### **Pitt Street North Over Station Development Stage 2 (SSD-10375) - Notice of Exhibition**

Thank you for your correspondence via the Major Projects Portal on 16 July 2020, requesting Transport for NSW (TfNSW) to review and comment on the above.

**Figure 31 | Car stacker and Loading dock layout (Source: RtS)**

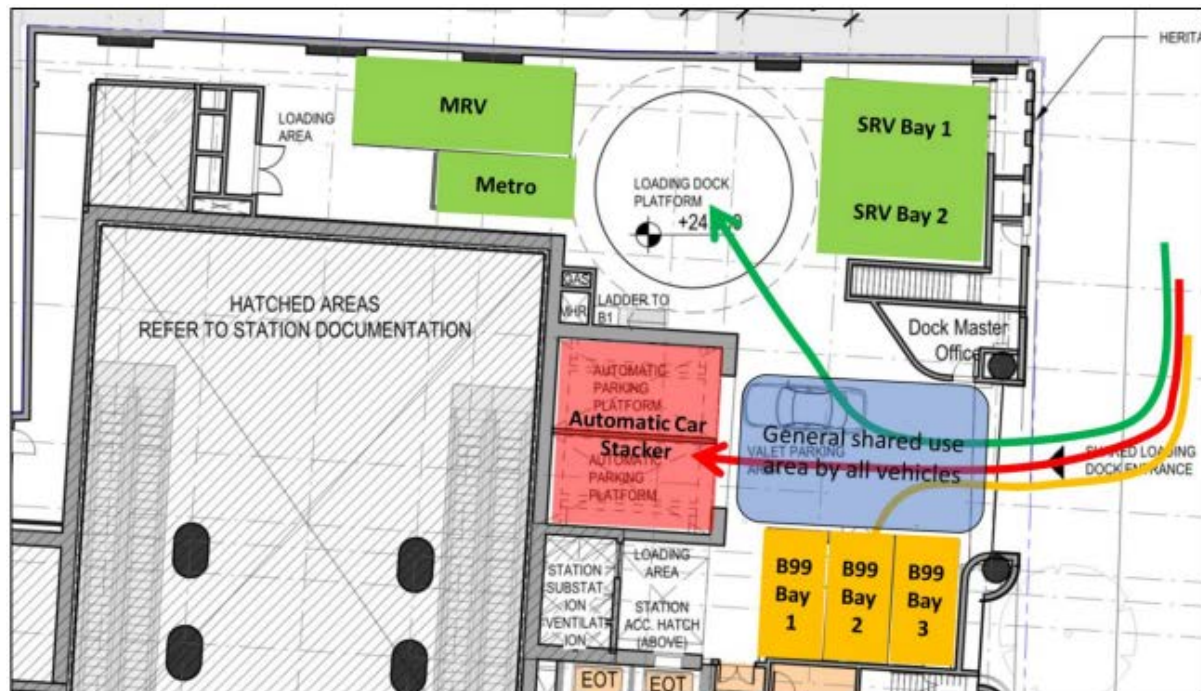
- The Delivery Service Plan will be managed by a dedicated on-site loading dock master through an integrated loading dock digital system notifying when deliveries are arriving and time allocation to specific loading requirements;
- Access to the automatic car stacker is provided via the loading dock. Car users accessing the automatic car stacker need to use the loading dock area; and
- It is proposed that two convex mirrors be placed on the footpath on Pitt Street to assist drivers exiting the loading dock to provide a better view of approaching cyclists and pedestrians.

- Pedestrian movements for accessing the automatic car stacker within the loading dock would cause pedestrian safety issues due to the service vehicle movements in particular reversing manoeuvres of these vehicles within the loading dock area;
- Given that the location of two convex mirrors is beyond the property boundary, a separate application should be made for approval of TfNSW for these mirrors;
- Queuing analysis for the loading dock vehicle movements needs to include queuing of vehicles that would be served by the automatic car stacker; and
- All new developments should not rely on on-street parking or loading zones. Kerb side restrictions can be changed at any time and the development should not rely on current kerb side restrictions to service the site.

It is requested that the applicant be conditioned to prepare a Car Parking, Loading and Servicing Management Plan in consultation with the Sydney Coordination Office within TfNSW by updating the Service Delivery Plan, prior to the issue of any Construction Certificate.
